Response to Submissions Report

The New Sydney Fish Market – Stage 2
MOD 6 – Temporary Construction Site
Accommodation

Submitted to NSW Department of Planning,
Industry and Environment
On behalf of Infrastructure NSW

27 January 2022 | 2210750

1. Project East
1:100

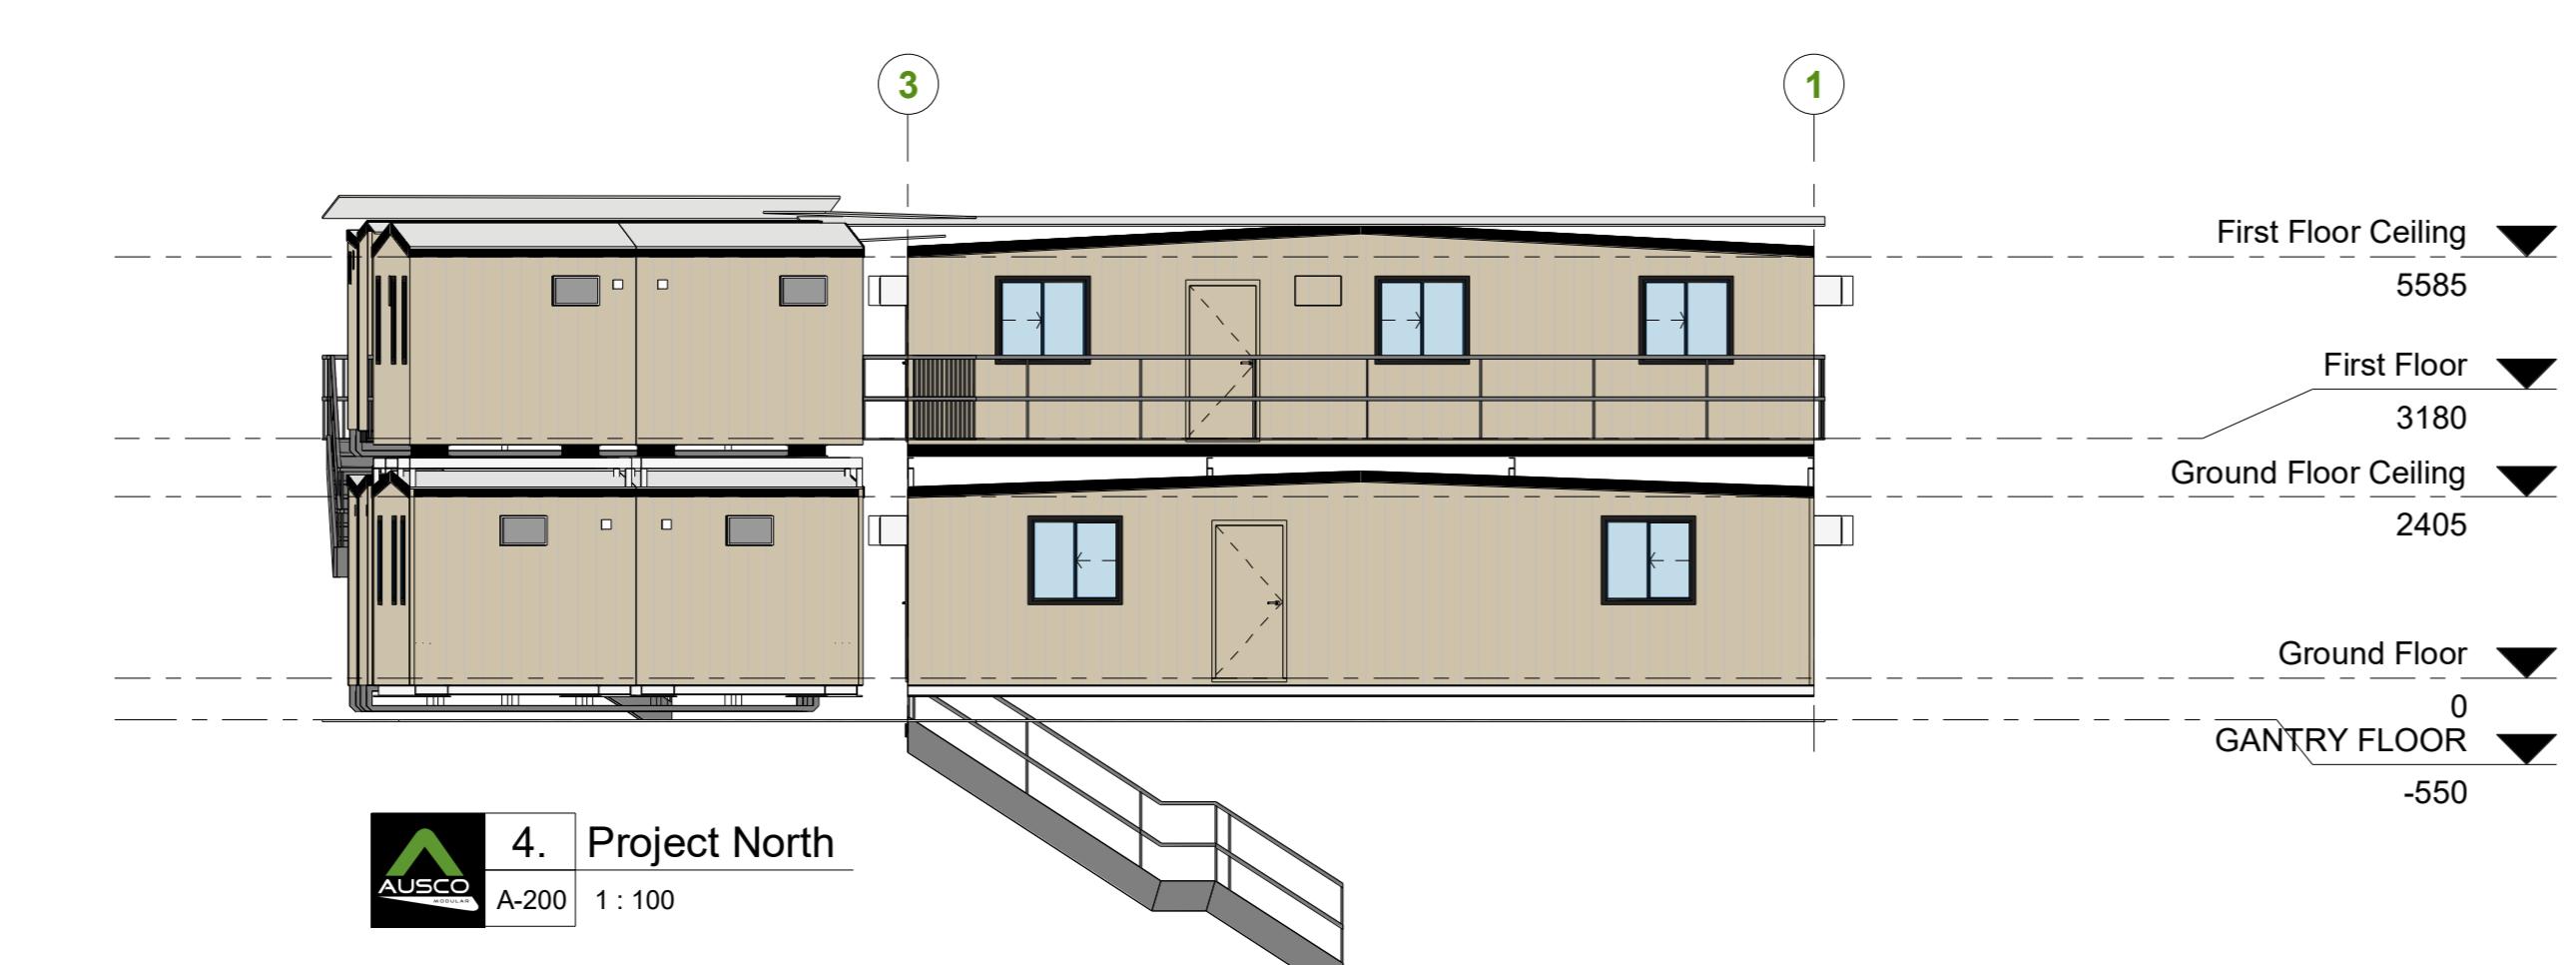
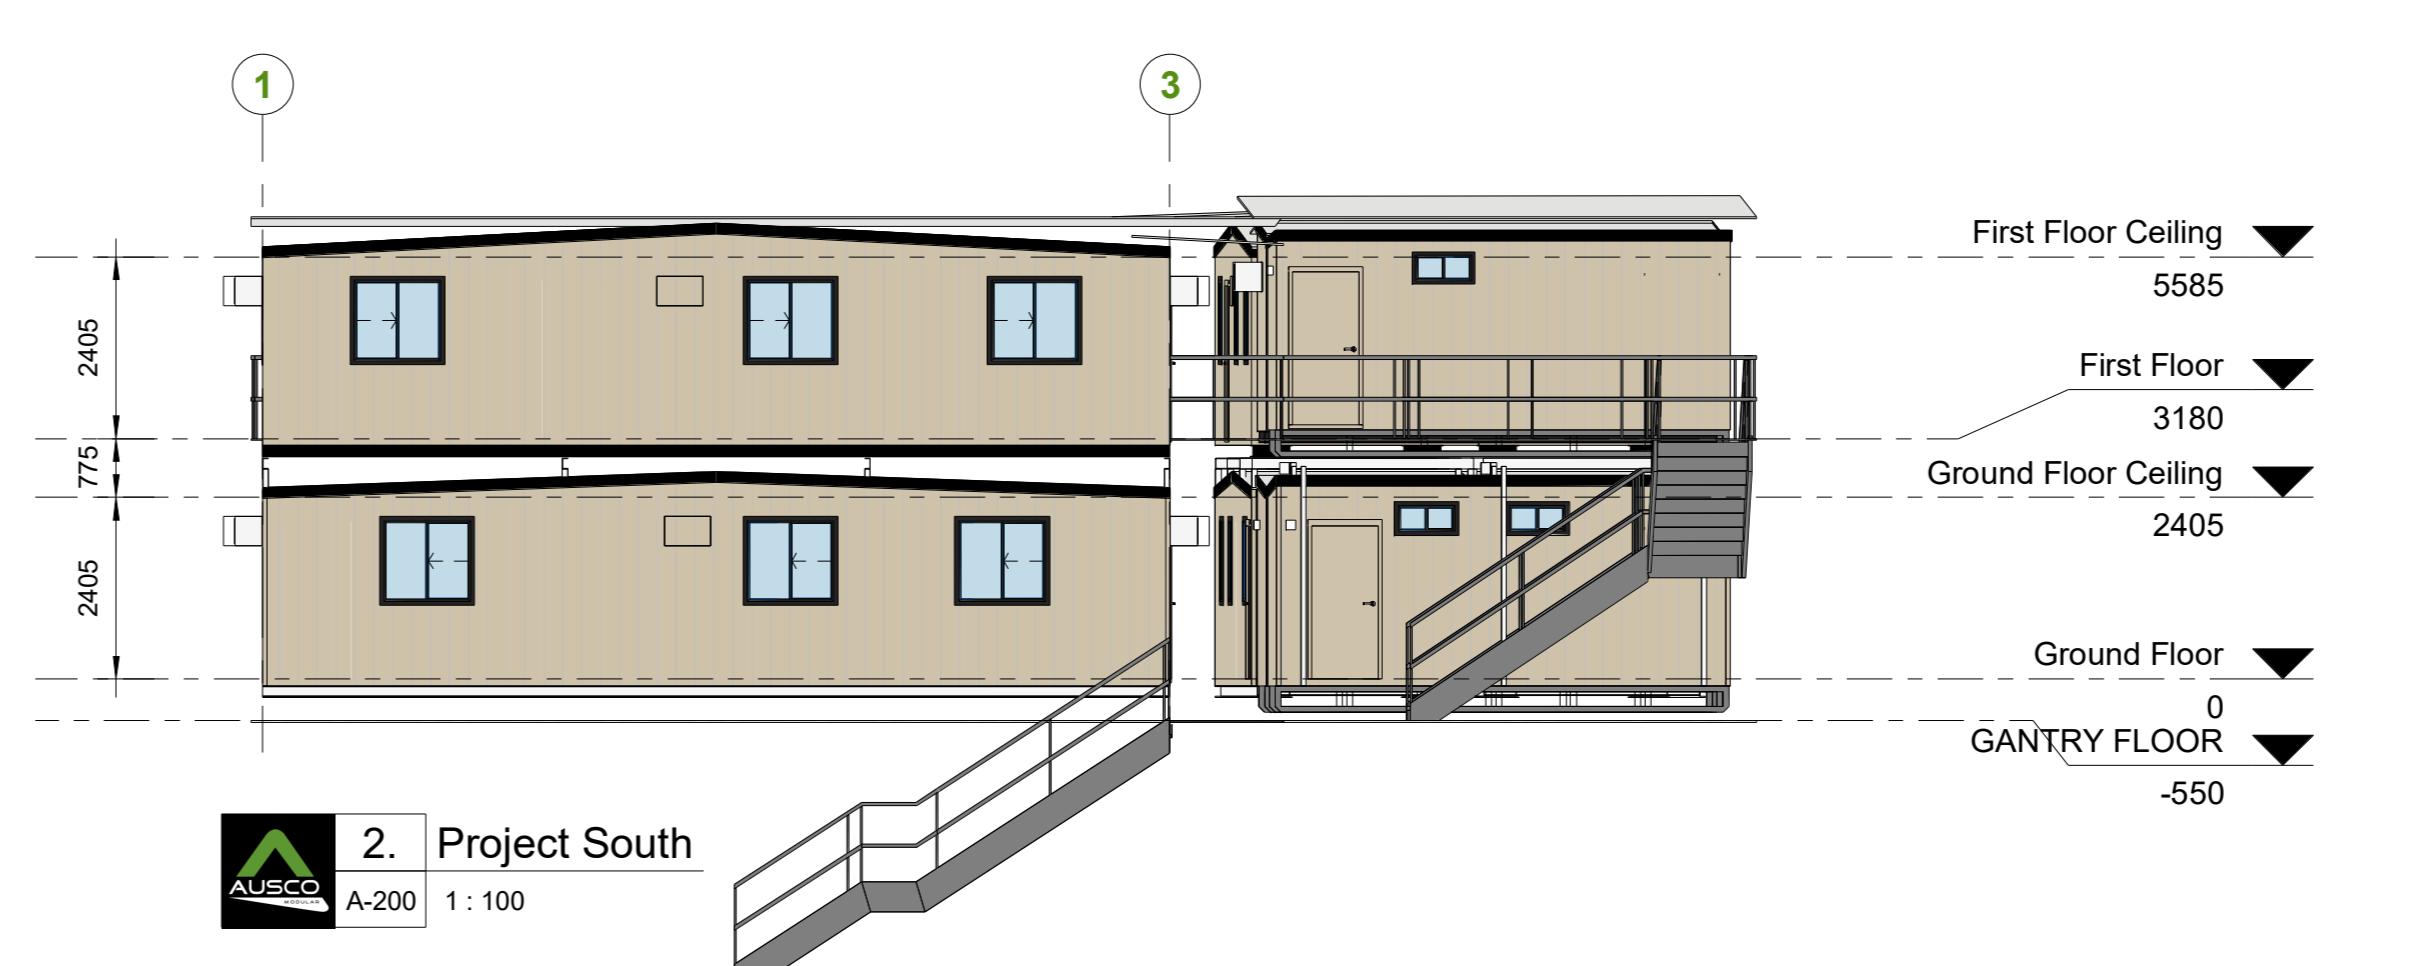
- Label the elevation drawings (Drawing No 110-112)

Comment: Elevations have been labelled.

ACCESS TO GANTRY DECK
GROUND FLOOR VIA
WALKWAY BRIDGE FROM
WITHIN SITE BOUNDARY

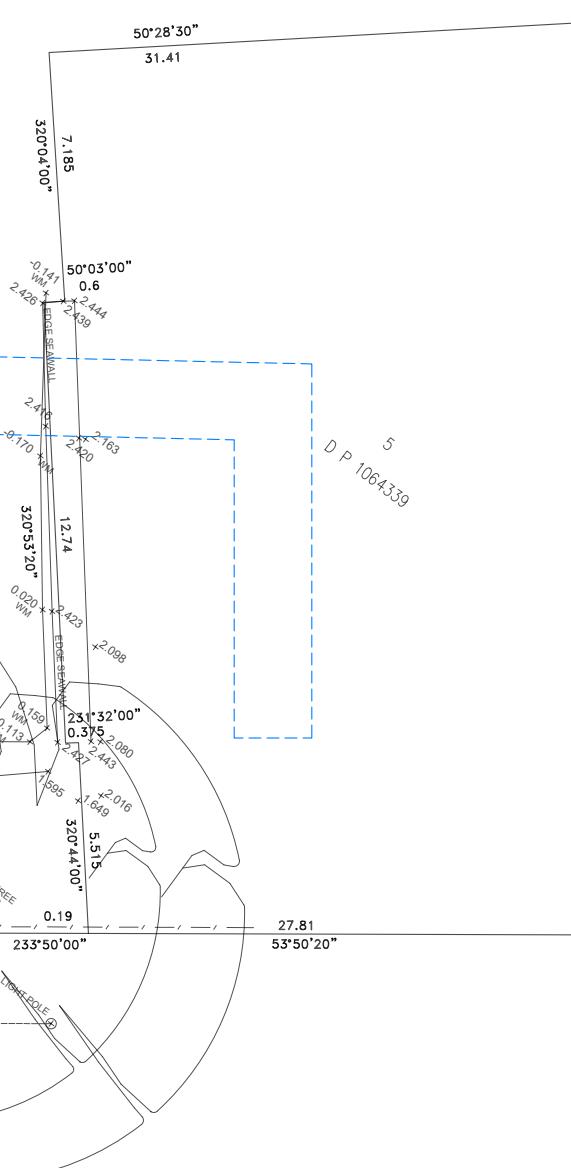
- Confirm how access is provided between the ground floor and first floor. The location of any staircase shall be shown on the architectural plans.

Comment: The Architectural Plans (**Appendix A**) have been amended to illustrate the location of stairs to access the ground to first floor.
